Developer Services
Southern Water
Sparrowgrove House
Sparrowgrove
Otterbourne
Hampshire
SO21 2SW

Your Ref
CM/6/18/PL
Our Ref
PLAN-022290
Date
19/04/2018

Proposal: Change of use to develop a concrete batching plant, with associated infrastructure, site offices & parking.
Site: Land at Northwood Farm, Yapton Road, Climping, BN18 0HR.
CM/6/18/PL

DRAWN BY:	D.G.N.	DATE	NOV 17
CHECKED BY:	A.C.	SCALE	1:250, 1:250@A1
DRAWING STATUS	PRELIMINARY		
DRAWING NO.	8975 / 200	REV.	P4

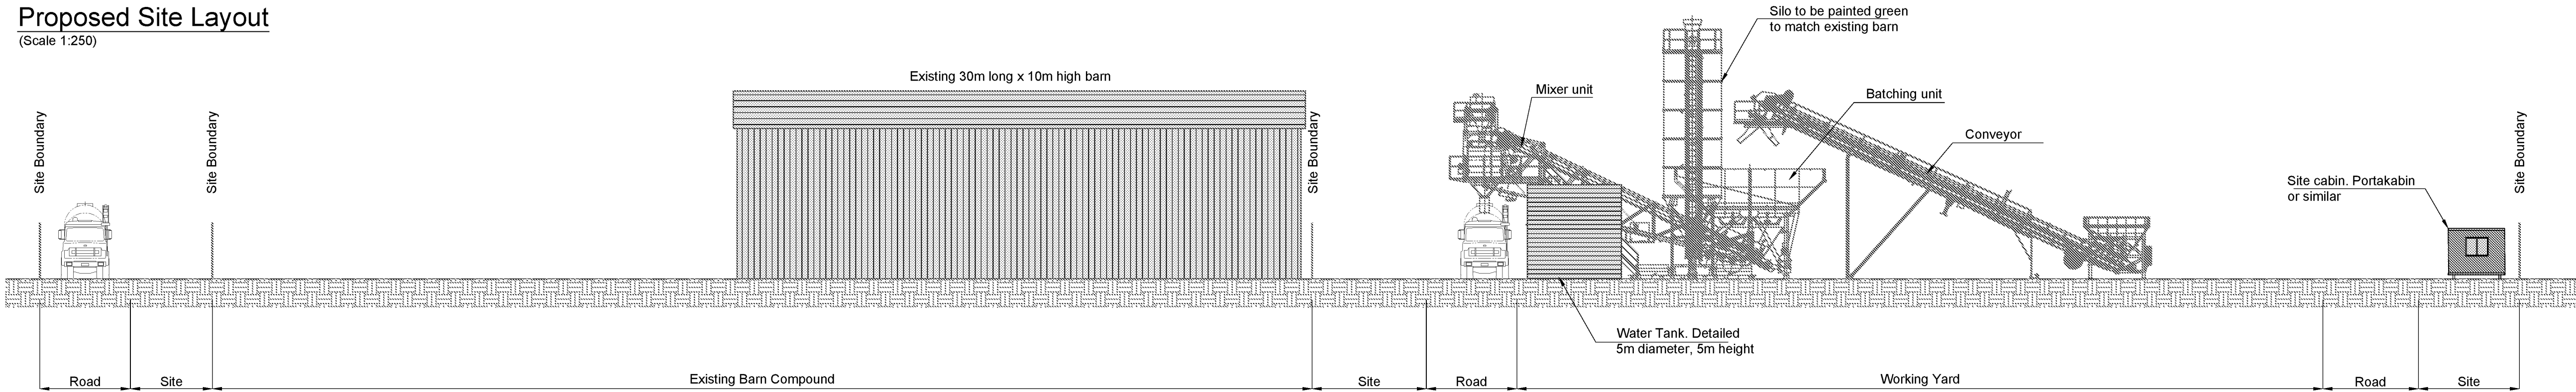
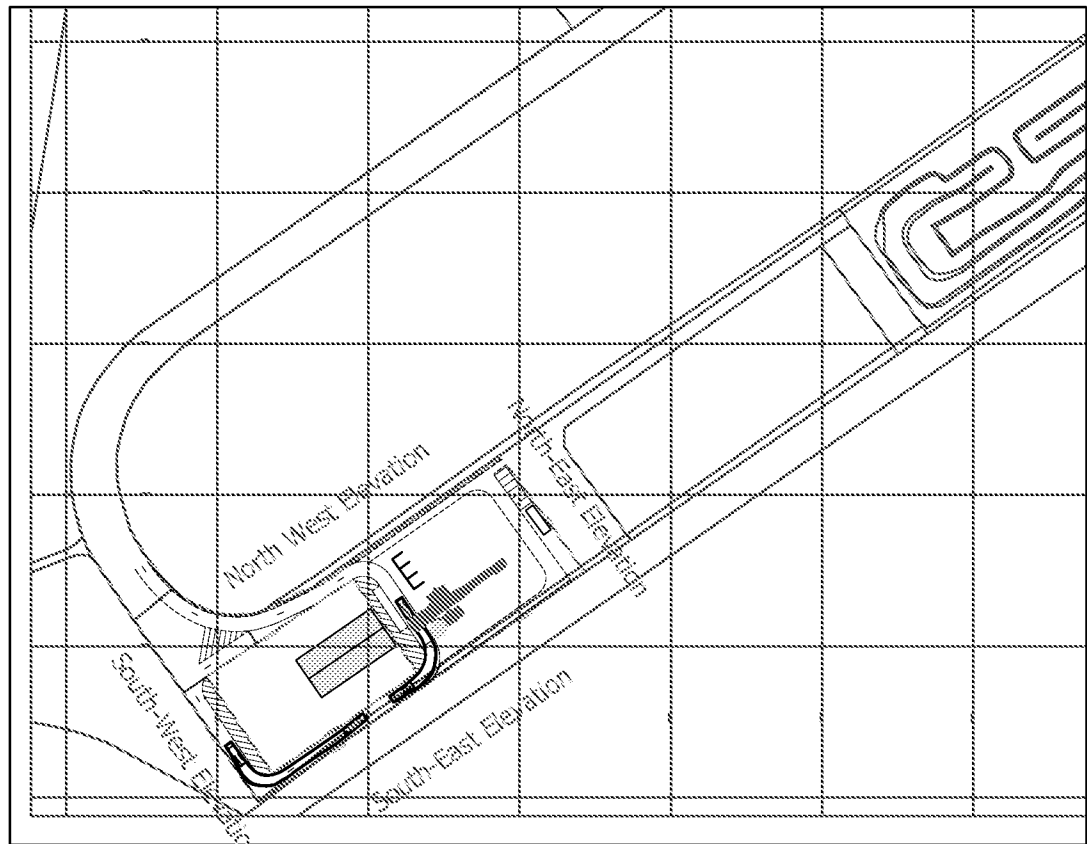
Drawing number 8975/200 Rev. P4 shows a barn built over or close to a 600mm critical sewer which is not acceptable to Southern Water. Please submit an amended plan to show:

- No development or new tree planting is located within 3.5 metres either side of the external edge of the foul rising main.
- No new soakaways are located within 5m of a public sewer.
